MOOLARBEN COAL COMPLEX UG4 ANCILLARY WORKS MODIFICATION

SUBMISSIONS REPORT

MOOLARBEN COAL PROJECT STAGE 1
PROJECT APPROVAL (05_0117) [MOD 15]

NOVEMBER 2019
Project No. MCM-16-15
Document No. 1004229

Figure 2.2 – Location of Surface Infrastructure associated with MOD 15

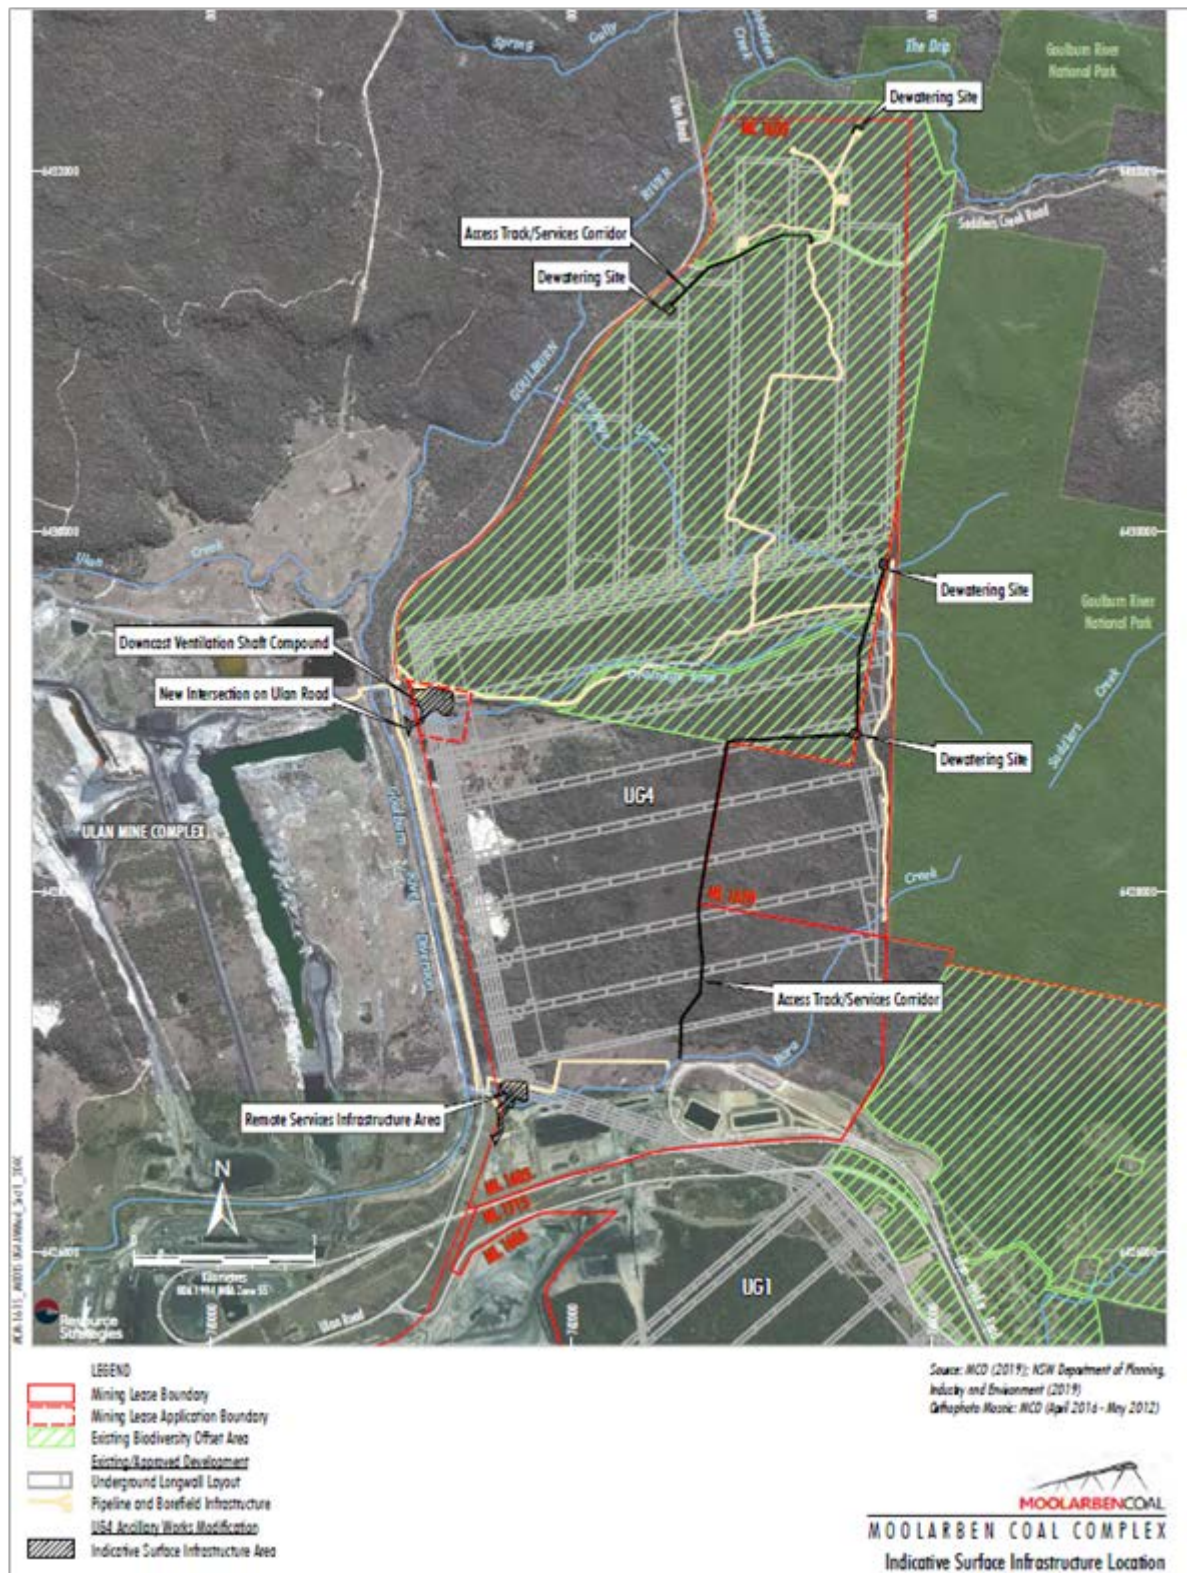
Roads and Maritime Services	
<p>The T-intersection at Saddlers Creek Road and Ulan Road proposed for access to the northern dewatering sites is unsatisfactory for the proposed use.</p>	<p>The intersection of Saddlers Creek Road with Ulan Road is a basic rural T-intersection, with no localised widening of the sealed surface of Ulan Road in the vicinity of the intersection.</p> <p>Vehicle movements at the intersection of Saddlers Creek Road with Ulan Road have been reviewed by TTPP (2019) with regard to the Austroads (2017b) warrants for rural intersection treatments. Traffic volumes at the intersection of Ulan Road with Saddlers Creek Road warrant the minimum preferred treatment, being BAL and BAR treatments in Ulan Road, regardless of the traffic generated by the Modification.</p> <p>The Modification would not generate any additional demand for left turn movements from Ulan Road into Saddlers Creek Road, and as such, any requirement to provide a BAL treatment at the intersection would be unrelated to the Modification.</p> <p>In addition, MCO would consult with RMS and Council prior to the commencement of construction at the northern bore sites (expected 2026) and confirm any traffic control measures or treatment required specifically for the Modification traffic.</p> <p>MCO will continue to monitor Saddlers Creek Road during construction activities and will implement relevant management measures in consultation with MWRC, as required that may include road watering and grading. Traffic management measures would be designed and implemented, taking into consideration the traffic volumes and short-term nature of the construction activity (i.e. 8 weeks for earth works and 12 weeks for construction), and may include (for example) provision of advance warning signs on Ulan Road to alert drivers to the presence of trucks turning in and out of Saddlers Creek Road, and traffic controllers to manage passing traffic during the movement of any larger equipment floats or cranes into or out of Saddlers Creek Road.</p>

Summary of Comment	MCO Response
Roads and Maritime Services	
<p>Roads and Maritime seeks further details regarding the extent of upgrades to Saddlers Creek Road and the upgrades need to account for future and continued use.</p>	<p>Saddlers Creek Road is a Crown Road listed as part of Mid-Western Regional Council's Unmaintained and Unformed Roads Policy. It should be noted that the Mid-western Regional Council did not comment on the current condition and proposed maintenance of Saddlers Creek Road.</p> <p>Notwithstanding, the results of the analysis conducted by TTPP (2019) demonstrate that the changes to traffic conditions that would occur as a result of the Modification along Saddlers Creek Road would be negligible. As such, MCO is not proposing to upgrade Saddlers Creek Road as part of the Modification.</p> <p>As stated above, MCO will continue to monitor Saddlers Creek Road during construction activities and will implement relevant management measures in consultation with MWRC, as required that may include road watering and grading. Traffic management measures would be designed and implemented, taking into consideration the traffic volumes and short-term nature of the construction activity (i.e. 8 weeks for earth works and 12 weeks for construction), and may include (for example) provision of advance warning signs on Ulan Road to alert drivers to the presence of trucks turning in and out of Saddlers Creek Road, and traffic controllers to manage passing traffic during the movement of any larger equipment floats or cranes into or out of Saddlers Creek Road.</p>

Mid-Western Regional Council	
<p><i>Council requests that the proposed intersection with Ulan Road be designed in accordance with Guide to Traffic Management Part 6: Intersections, Interchanges and Crossings (Austroads, 2017), and that the proponent consult with NSW Roads and Maritime Services and Council to obtain all relevant approvals for the works to be undertaken. All works will be the full cost of the proponent.</i></p>	<p>MCO agrees and accept MWRC's request.</p> <p>As stated in Section 2.1 of the Modification Report:</p> <p><i>The new intersection with Ulan Road would be designed to be consistent with the Guide to Traffic Management Part 6: Intersections, Interchanges and Crossings (Austroads, 2017) and in consultation with NSW Roads and Maritime Services (RMS).</i></p> <p>Section 6.6.3 of the Modification Report also confirms:</p> <p><i>MCO would confirm the design of the proposed new intersection with Ulan Road as part of the approval required under Section 138 of the NSW Roads Act, 1993 in consultation with RMS and Council.</i></p> <p>The above responses to RMS also provide further detail regarding the information which MCO will provide as part of the Section 138 approval process.</p>
